Southampton Archaeology Unit

17-19 Between Towns Road, Cowley

Comments on Sumo survey 2019 Report 16403 by Dr AD Russel BA PhD MCIfA.

Title: GPR Survey - Timeslice at 0.60m

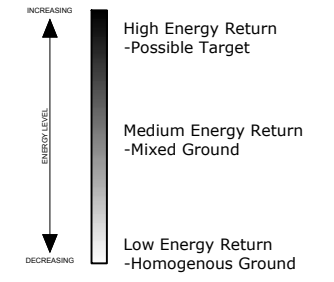
2. The GPR data looks impressive, and seems to have located modern drains and service runs well, but I would have expected to see the two Roman ditches that left the south side of the site to the north in the 0.6m, 0.7m, and 0.8m timeslices. The top of the natural is about 0.6m below the surface and the ditches were 300-400mm deep. Most of the anomalies showing in these lower timeslices can be seen higher up, suggesting they are more recent disturbances.

Scale: 0 metres 15 1:300 @ A3	Fig No: 13
-------------------------------------	---------------

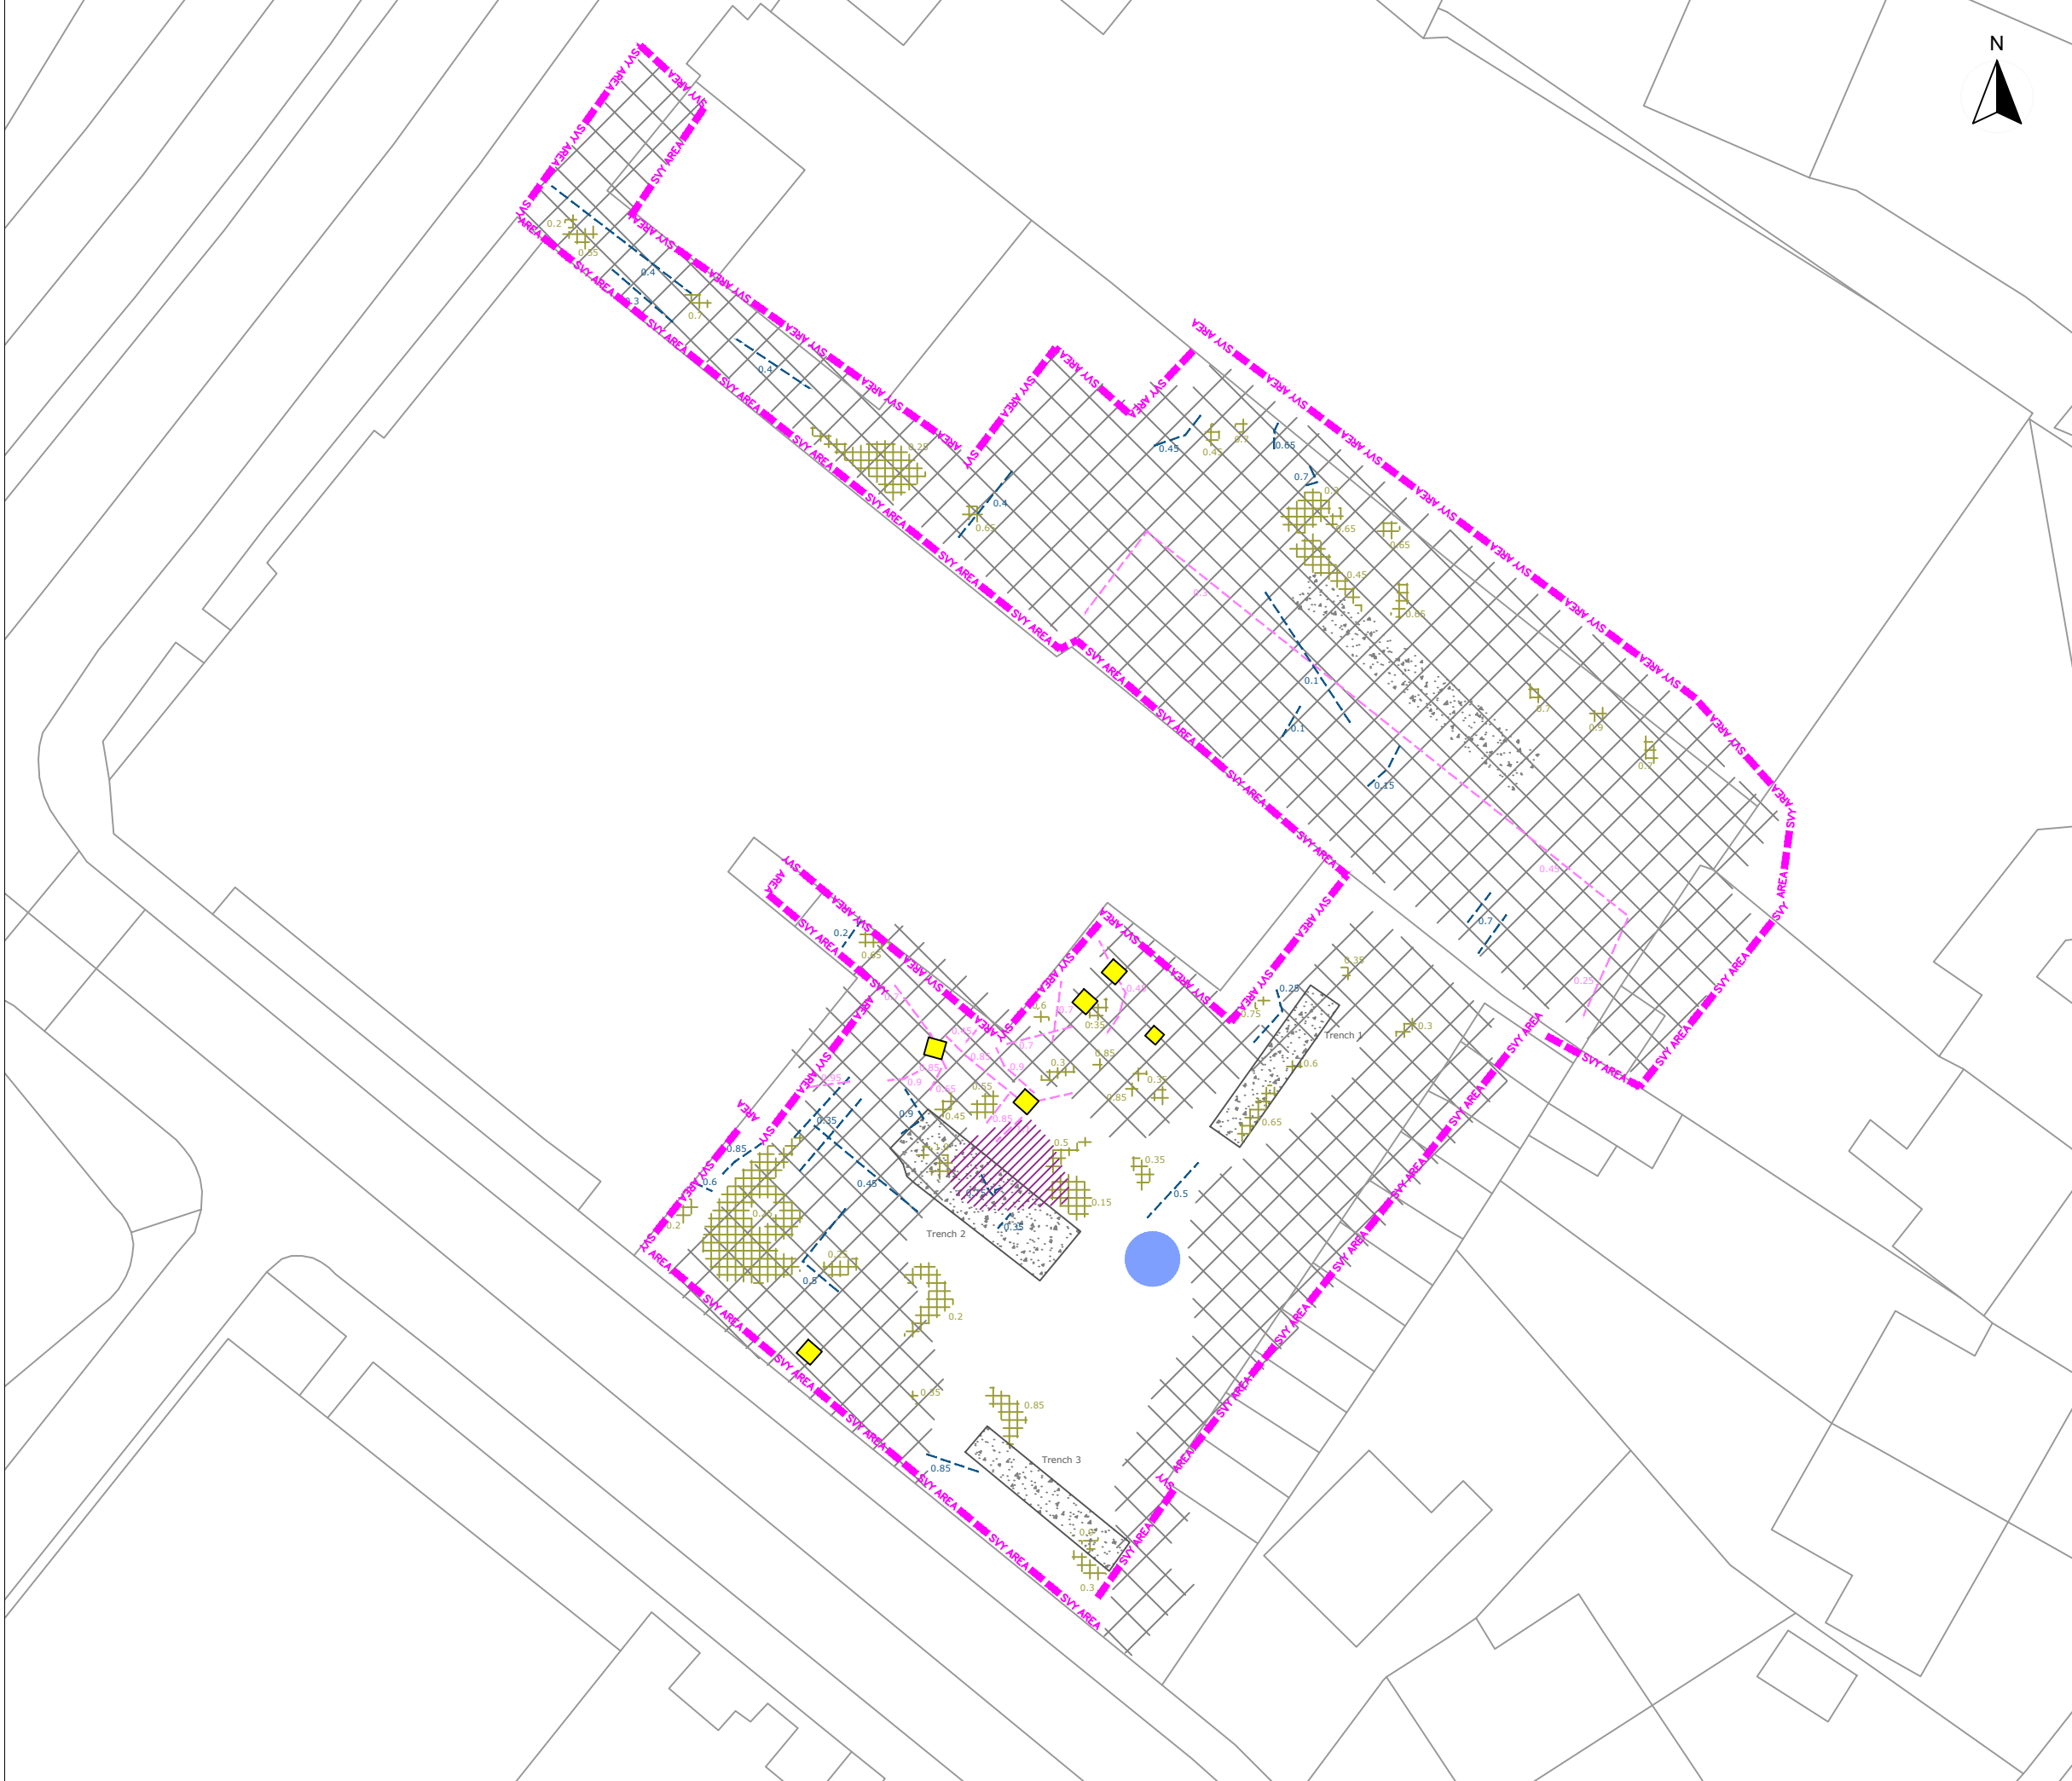
3. The data suggests that there are no kilns on the site as the strongest magnetic signal comes from a pit containing pottery, but does suggest more such pits are present. The data also suggests that the geophysical methods cannot detect the Roman ditches probably due to the ground conditions, with the ditches cut through fairly soft sand and backfilled with the same. It may be that the pits detected by the magnetic survey are dumps of pottery in the ditches.

Plan below shows the Sumo 'Interpretation of GPR fig 13' combined with results to the north, with Roman ditches highlighted in blue.
